WINSOME FILING NO. 2, LOT 1  
 REZONE MAP  
 SW 1/4 of SECTION 19, TOWNSHIP 11 SOUTH, RANGE 64 WEST OF THE 6TH P.M.

# V1\_Zoning Map Redlines.pdf Markup Summary

**WINSOME FILING NO. 2, LOT 1
REZONE MAP**
SOUTHWEST ¼ OF SECTION 19, TOWNSHIP 11 SOUTH, RANGE 64 WEST OF THE 6TH P.M.

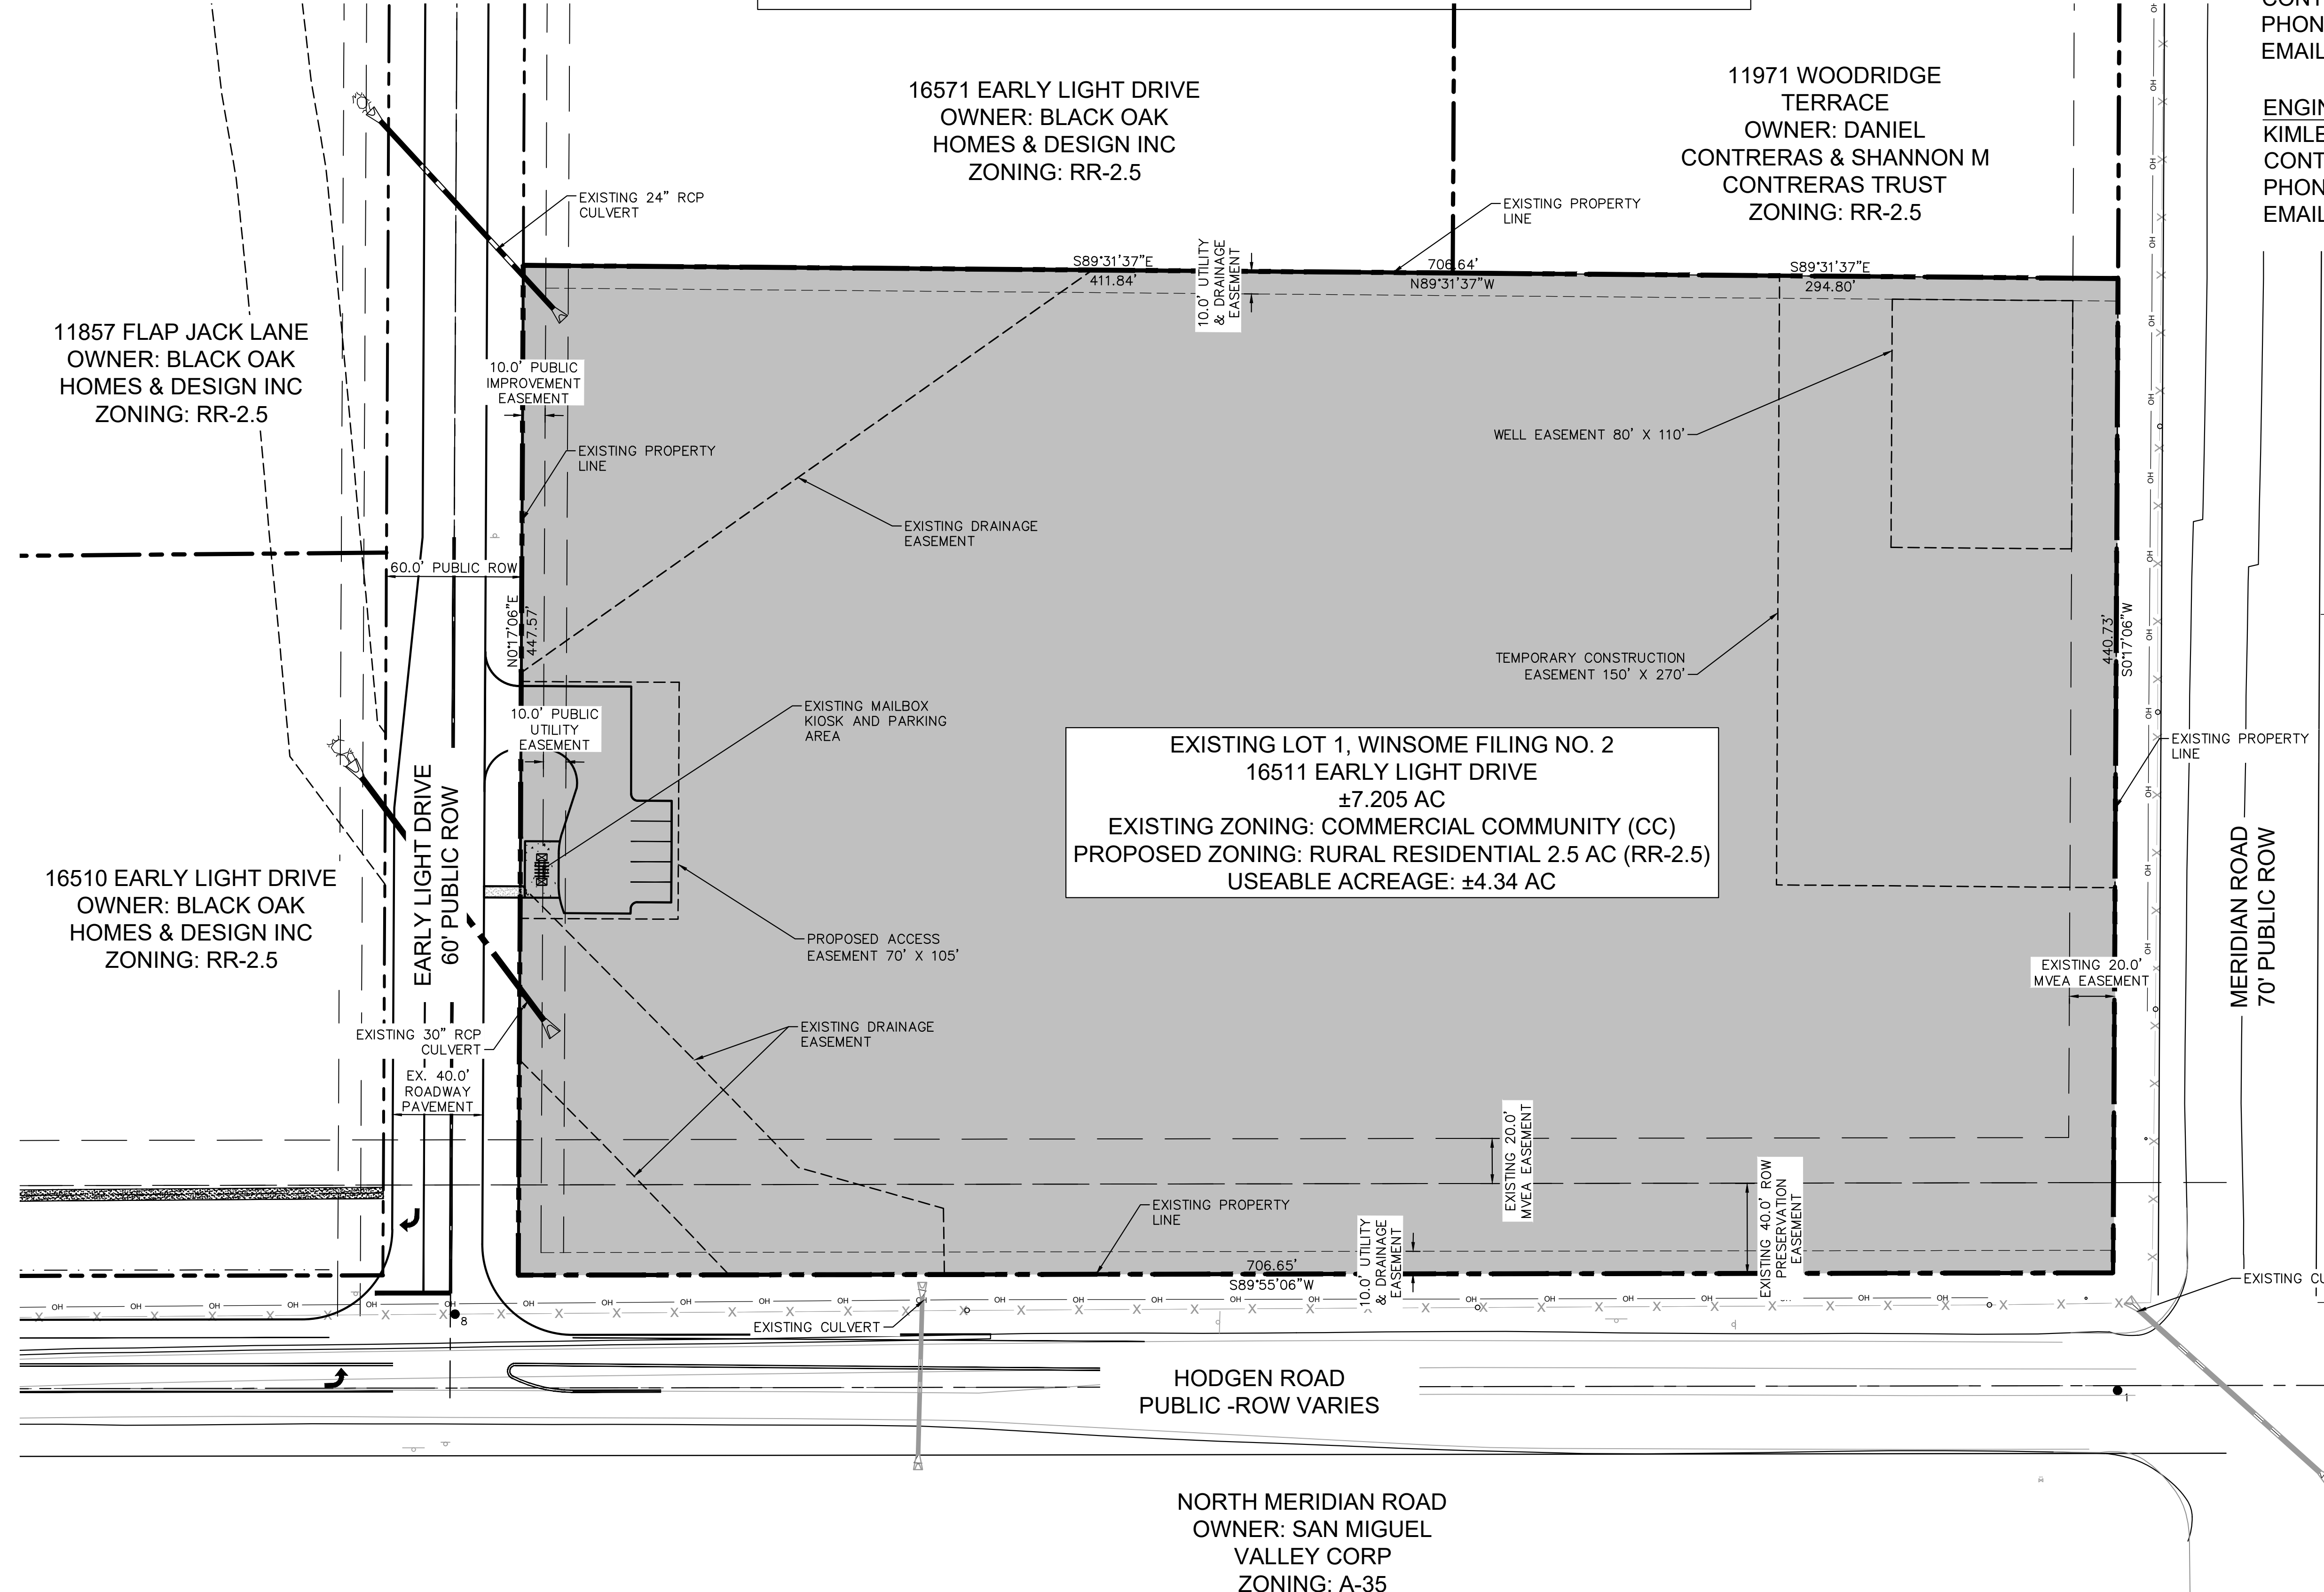
Per the checklist, add existing and requested zoning boundary description of the subject property, which shall illustrate the legal description.

SW 1/4 of S

SW 1/4 of

Per the checklist, add existing and requested zoning boundary description of the subject property, which shall illustrate the legal description.
